Further to a meeting of its Planning Committee Advisory Group held on 14th December 2021 and pursuant to a scheme of delegation dated 4th May 2021, the Clerk submits the attached comments on behalf of the Parish Council in respect of the following applications:

P/153/21/RES. Land south of Summer Lane and West of Pagham Road Pagham. Approval of reserved matters (appearance, layout, landscaping and scale) following outline planning permission P/140/16/OUT for the erection of 375 No dwellings, together with public open space, play space, drainage, parking and associated infrastructure, landscape, ancillary and site preparation works, with access off Pagham Road. This site may affect a Public Right of Way.

P/167/21/RES. Land south of Summer Lane and West of Pagham Road Pagham. Approval of reserved matters (appearance, layout, landscaping and scale) following outline planning permission P/140/16/OUT for the erection of 375 No dwellings, together with public open space, play space, drainage, parking and associated infrastructure, landscape, ancillary and site preparation works, with access off Pagham Road (alternative to P/159/21/RES). This site may affect a Public Right of Way.

The C

Proposed View F from Drawing 21.129.109 Showing Framed View of St Thomas à Becket Church

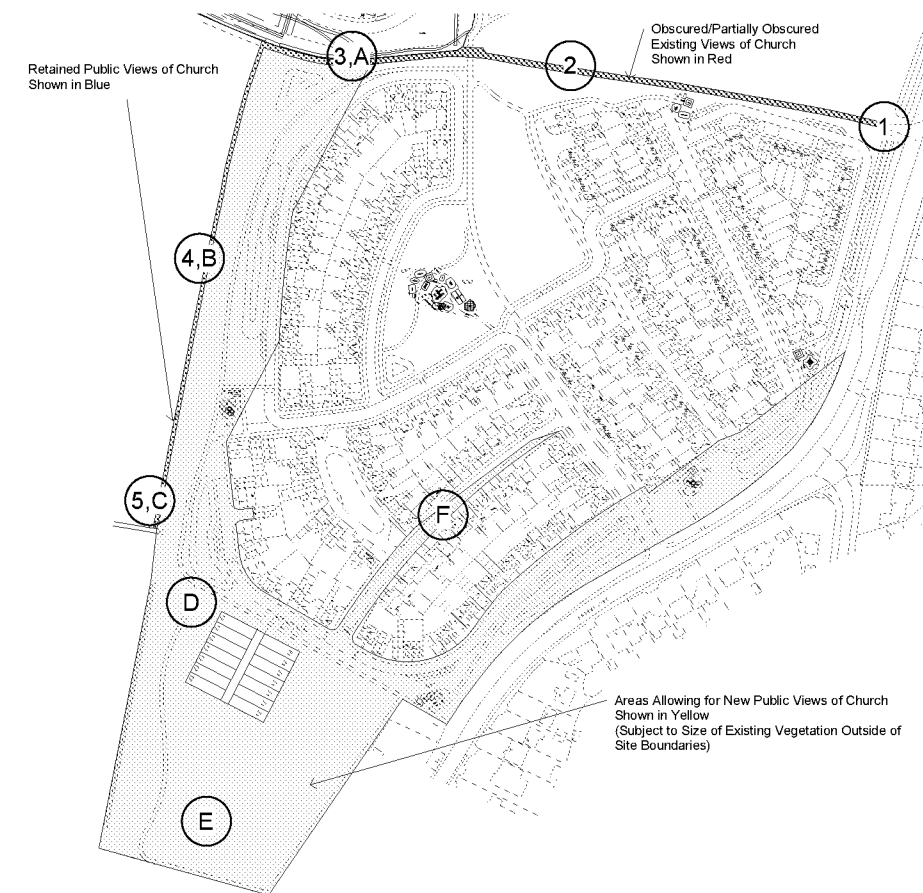
The views of the historic St Thomas A Becket church in Pagham are not respected by the proposed development. There is no evidence presented as to how the views will be preserved for properties within the development. In addition to the views of the church, the view from the footpath in the opposite direction includes the Chichester Cathedral. This will be obliterated by the development.

Comparison Diagrams

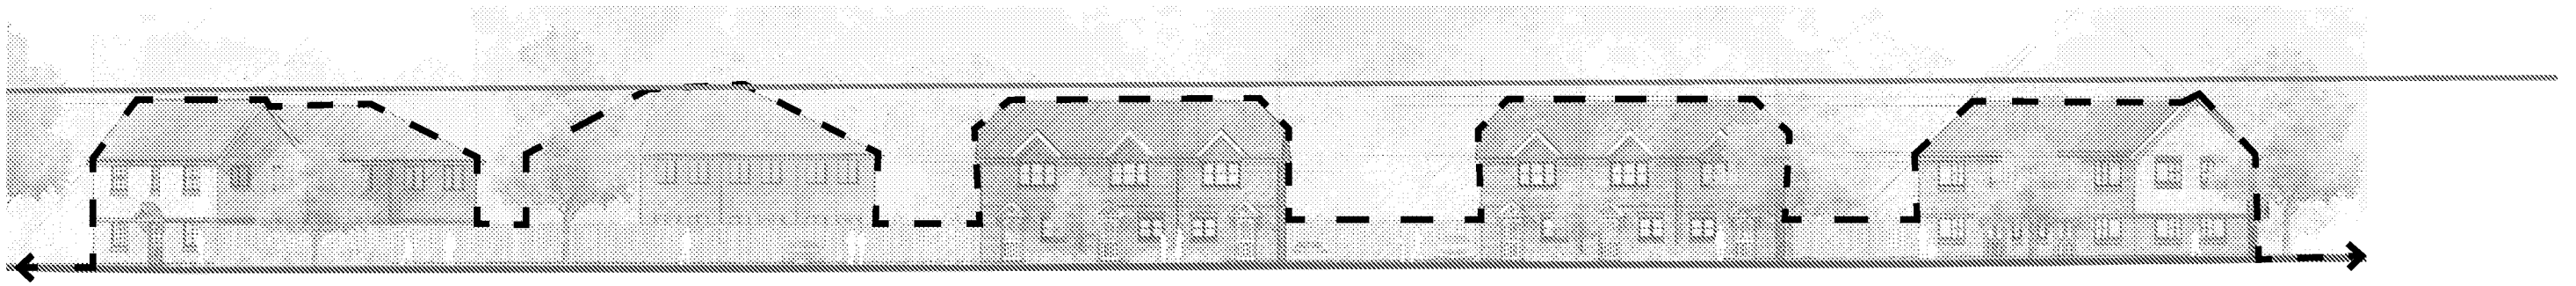
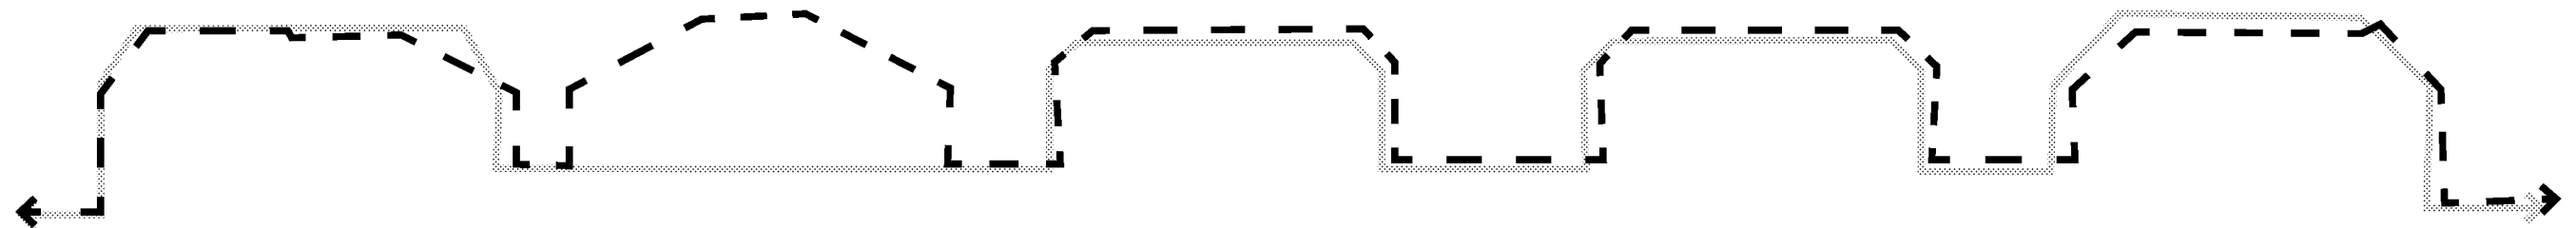
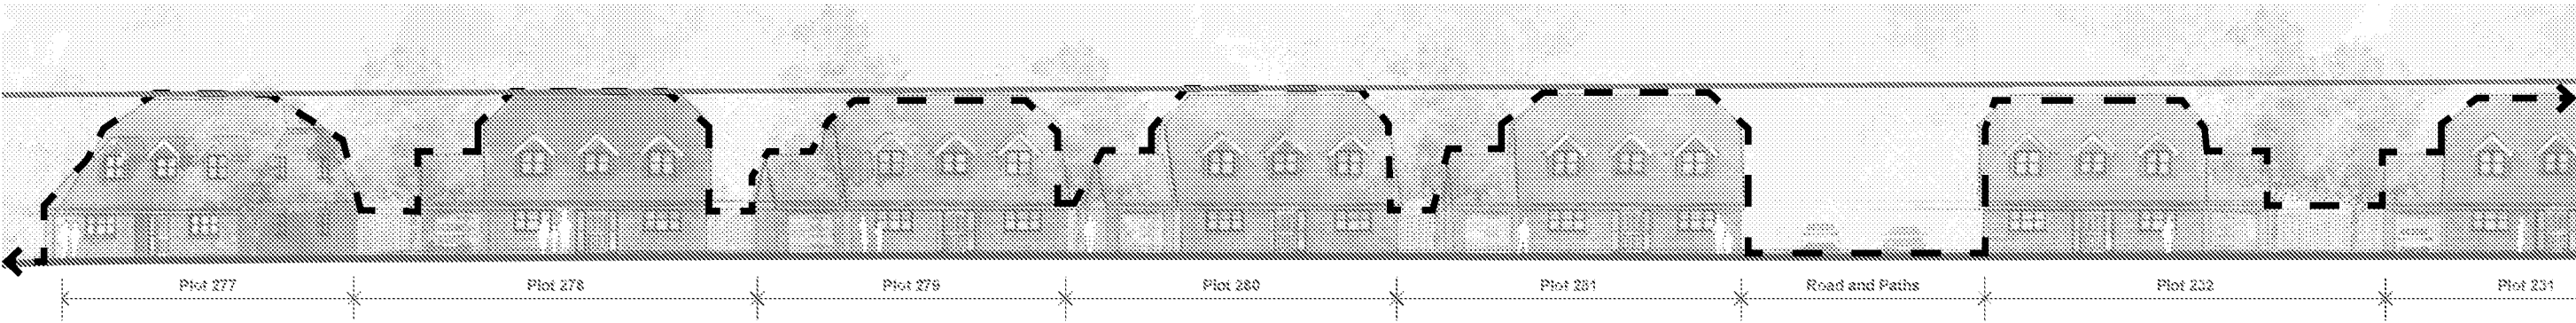
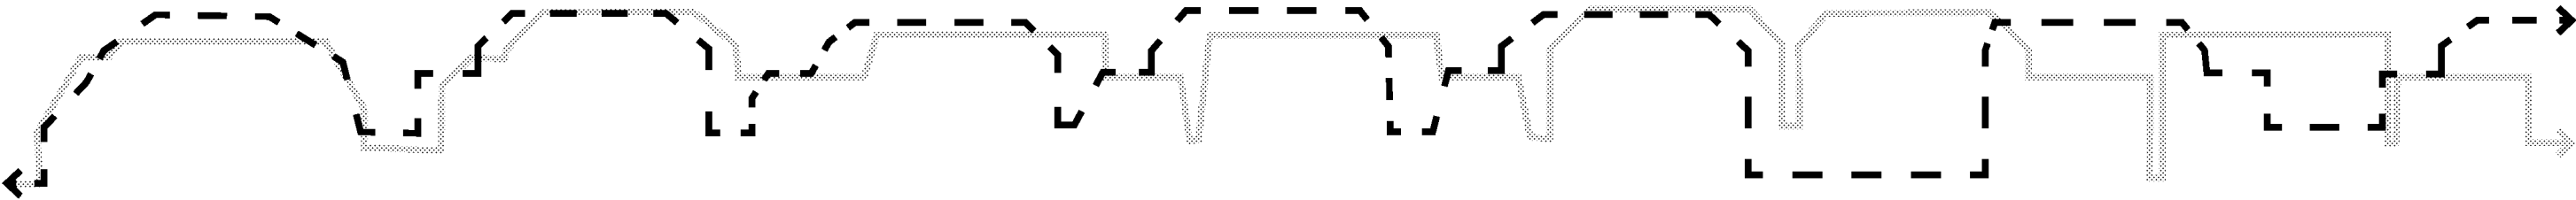
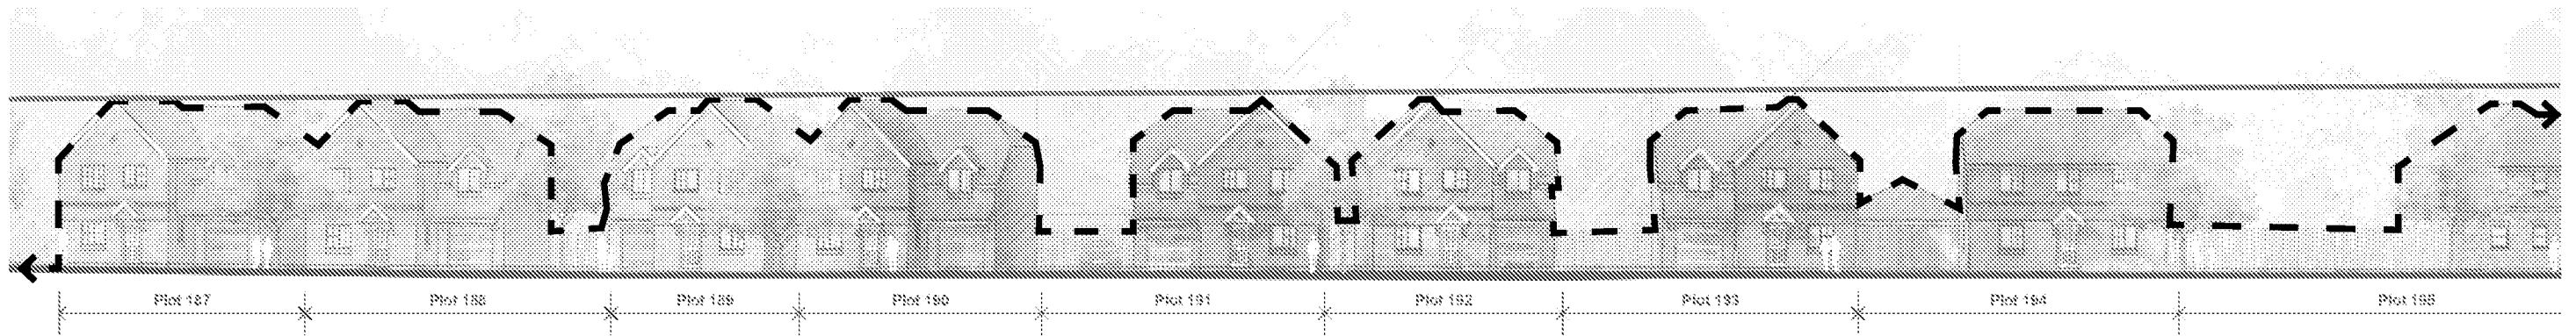
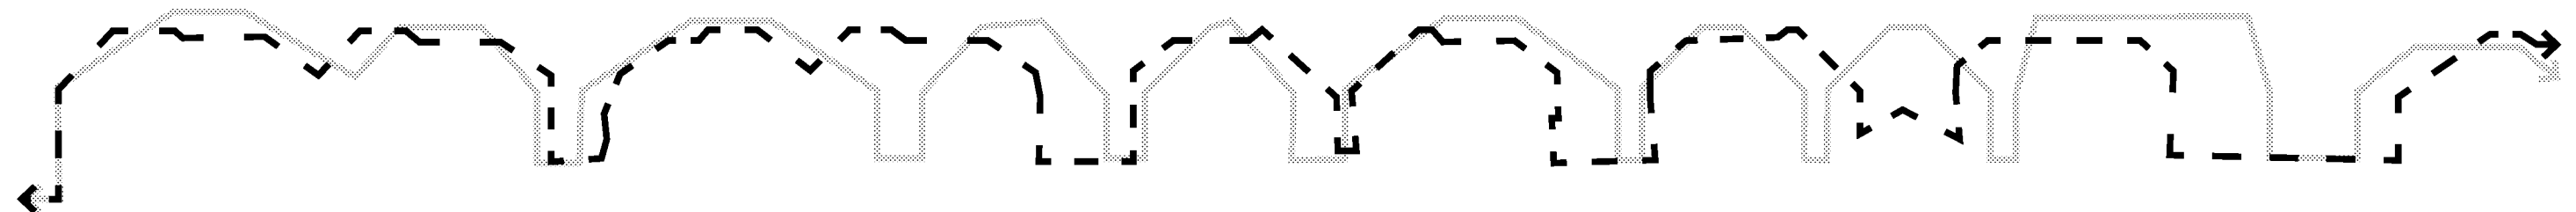
The standard of design of the properties is poor – Councillors felt the properties were boxy, unimaginative and the addition of tile hanging, cladding and other design features did not alleviate the impression that the units were too similar. In a village setting such as Pagham, design should be less urban. There was insufficient character detail, particularly on the rural edge. Too much red brick was proposed. The roof heights were too high.
